**Consultation Response from KC,
Ecology Unit**
**2026/92441 Disused Railway Embankment, off Crosland Factory Lane to Fold Farm Lane,
Netherton, Huddersfield, HD4 7FB**
**Formation of accessible, 755m long path for walking, wheeling and cycling primarily along
the top of a disused railway embankment**
Date Responded: 01/10/2026
Responding Officer: Z. Hanshaw
Responding Ref: 2610/02

Figure 1 Plan showing locations of trees to be removed - north

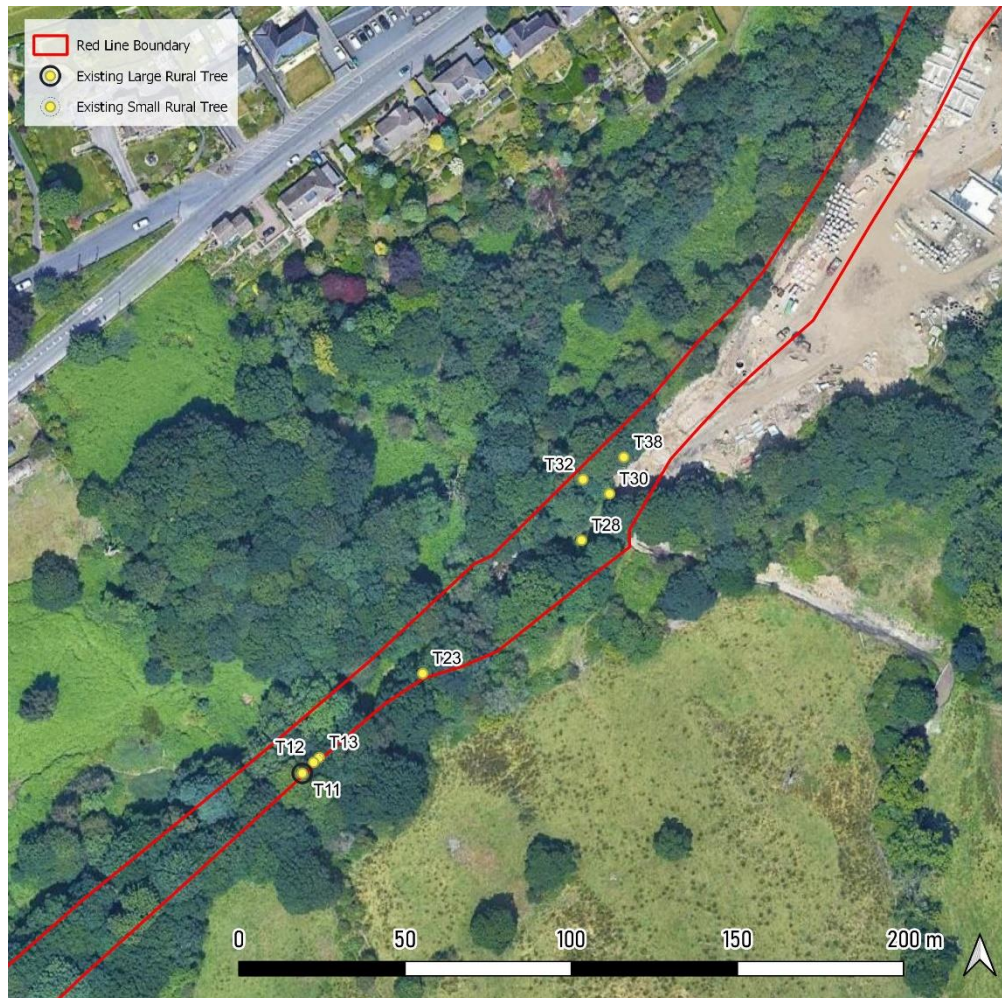
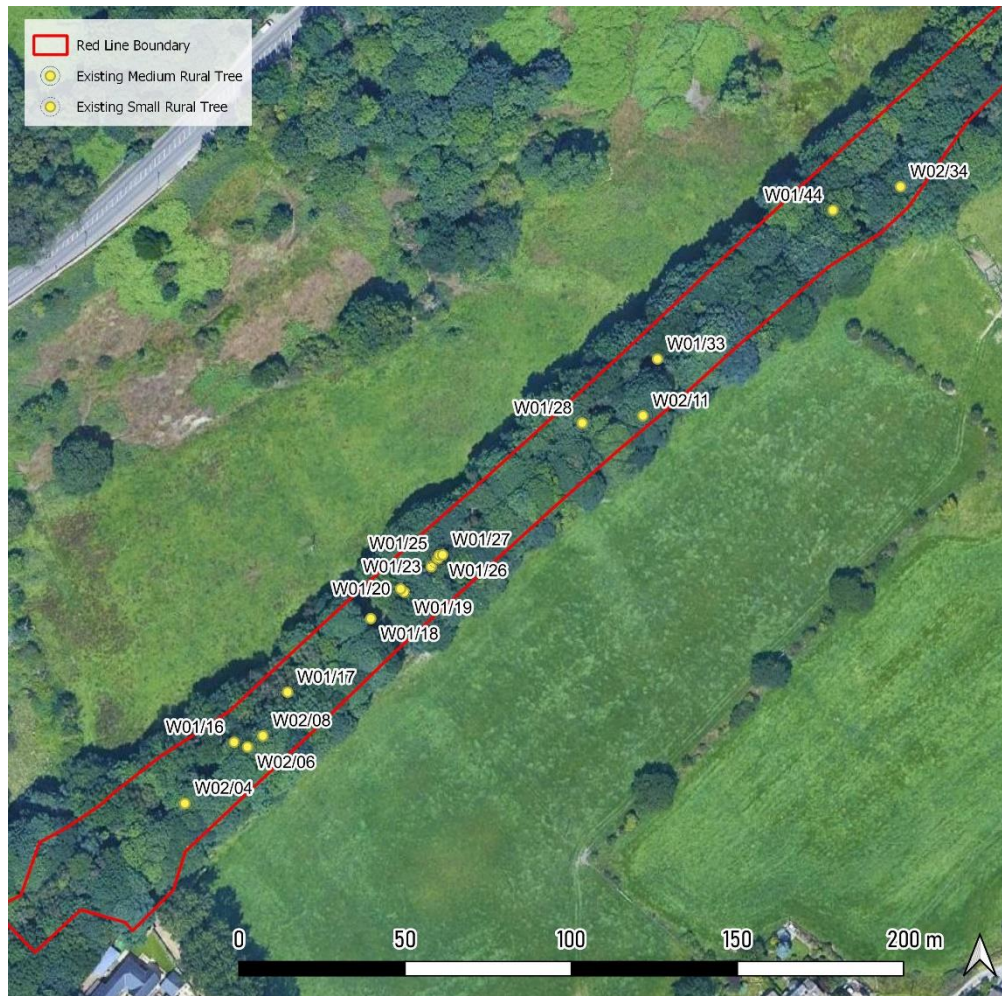
The Preliminary Ecological Appraisal also states that further bat surveys are required on the trees to be removed, and in the preapplication response sent by KC Ecology, hibernation surveys were also recommended. No further bat surveys have been undertaken, and no information is provided in the ecological reports on the trees to be removed. Further information on the bat roosting suitability of the trees to be removed, and further bat surveys of the tunnels need to be provided prior to determination.
